File Ref. No: BFS16/2376 (11937)
TRIM Doc. No: D16/79187
Contact: Station Officer Mark Castelli

25 October 2016

**Australian Habitat and Taronga Wildlife Retreat
Bradleys Head Road, Mosman (SSD 15_7419)**

Figure 3-3: Proposed site plan

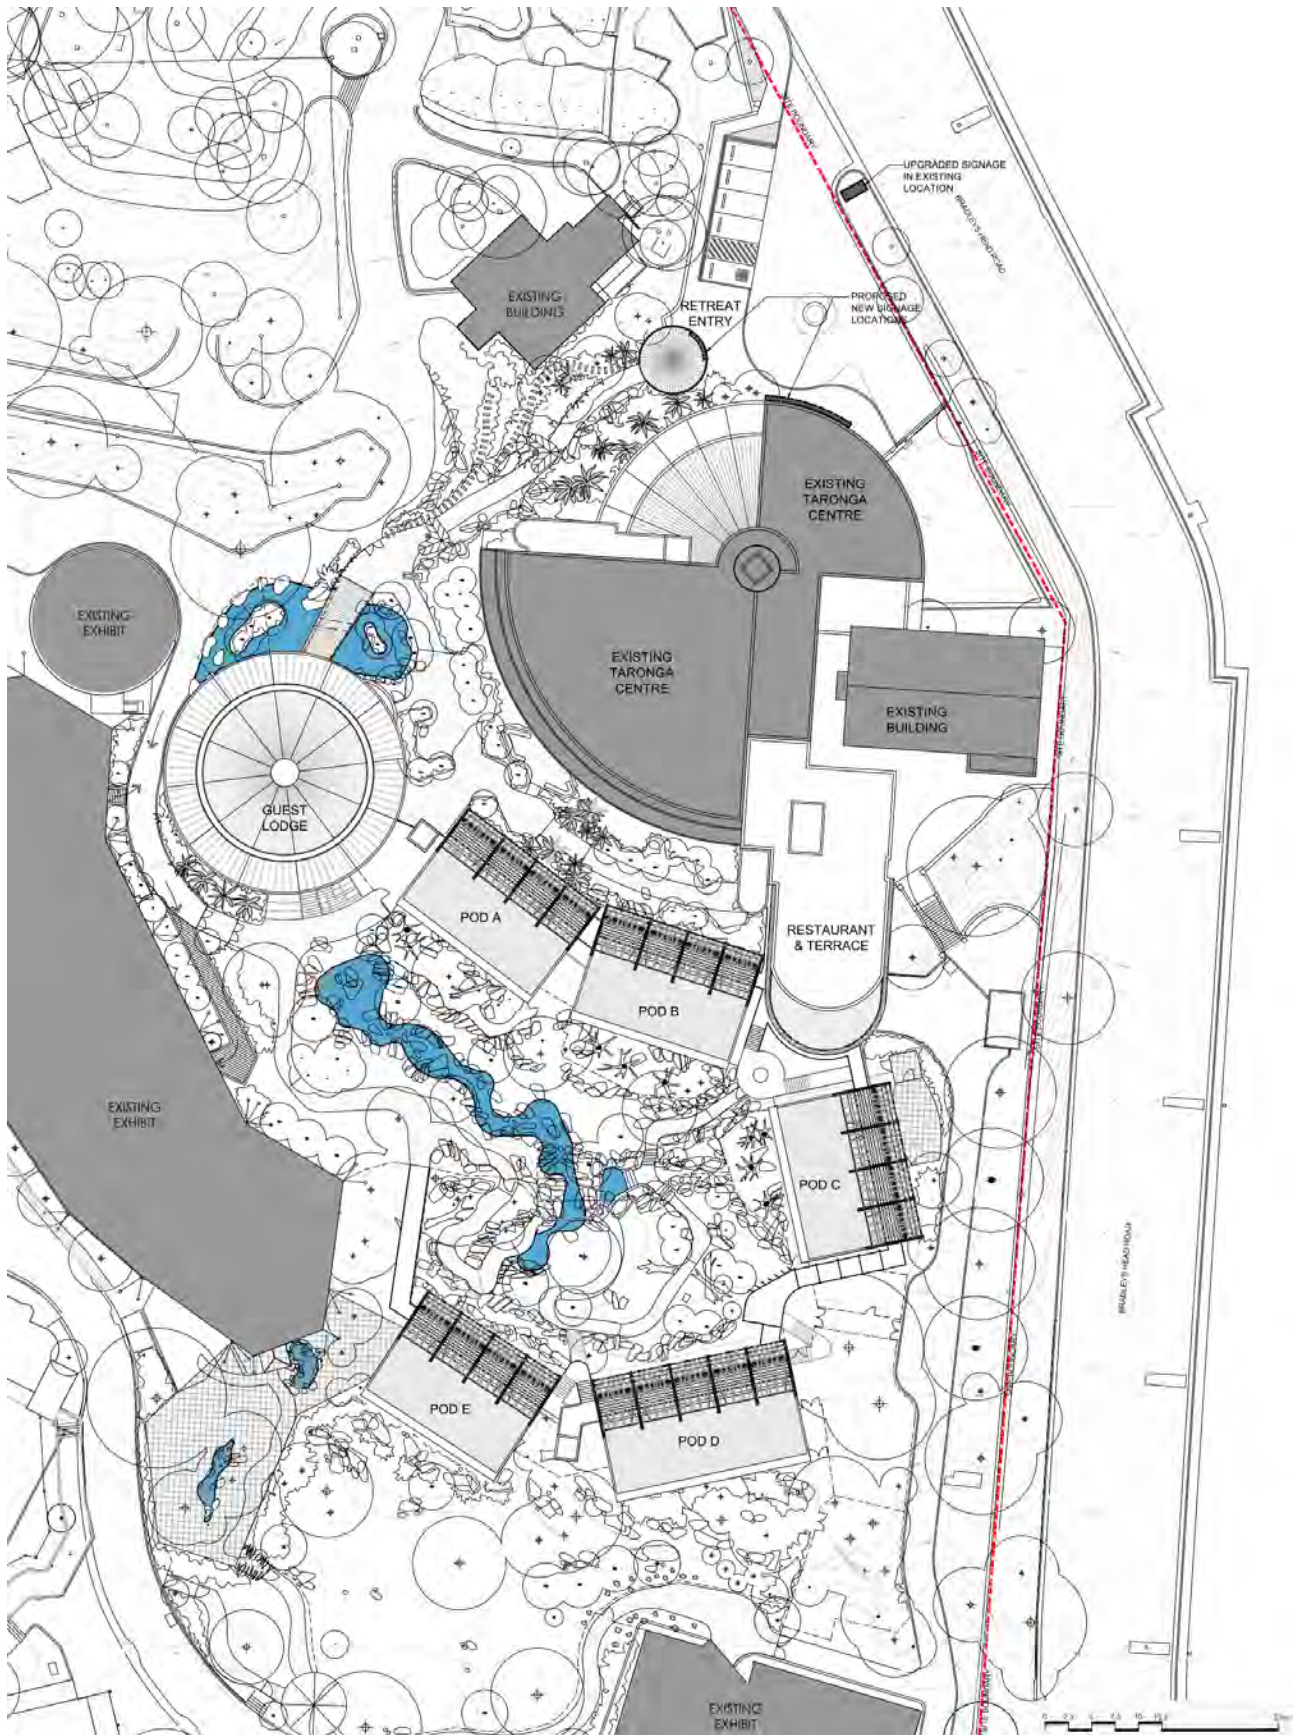
1. With the exception of Item No.4 FRNSW advises that the responses detailed in the Revised Safety Strategy Report satisfactorily addresses our previous comments.
2. In regard to Item No.4, it appears that our original comment has been misinterpreted.
The intent of our original comment was to ensure that FRNSW personnel, during a response to a bushfire threat, will have unimpeded and safe pedestrian access to external hydrants that will be located in vegetated areas that are proposed to surround the subject building.

FRNSW previous recommendation (i.e. that interlinked pedestrian pathways to all fire hydrants and the connection to a carriageway roadway be provided) was within the context of connecting internal pedestrian pathways to the Taronga Zoo's internal roadway network. FRNSW understands and acknowledges that external public roadways will, by necessity, be separated from the site by perimeter fencing (in this instance heritage listed fencing).

The above recommendation was intended to ensure that FRNSW personnel can quickly gain access to the subject building, during a bushfire incident, via the site's internal vehicle carriageway network and then via foot to strategically located fire hydrants as circumstances require on the day. We acknowledge that local FRNSW personnel will be familiar with accessing and navigating the site, however a response by local FRNSW personnel cannot be relied upon at any time, particularly during bushfire danger periods. In order to facilitate safe and rapid fire service intervention the site's fire systems must be designed and constructed to be functional and accessible to FRNSW personnel who may be unfamiliar with the site.

- That appropriate internal pedestrian pathways are installed from the site's internal vehicle carriageway network to the fire hydrants detailed in Item No.3 of Appendix 'A' of Attachment 'I' of the RtS. In addition, and to ensure that FRNSW personnel can quickly relocate to fire hydrants as circumstances may warrant, that all hydrants installed specifically to protect the subject development's facade be also interconnected by footpaths that minimise travel pedestrian distances between hydrant points (i.e. from footpath to footpath).
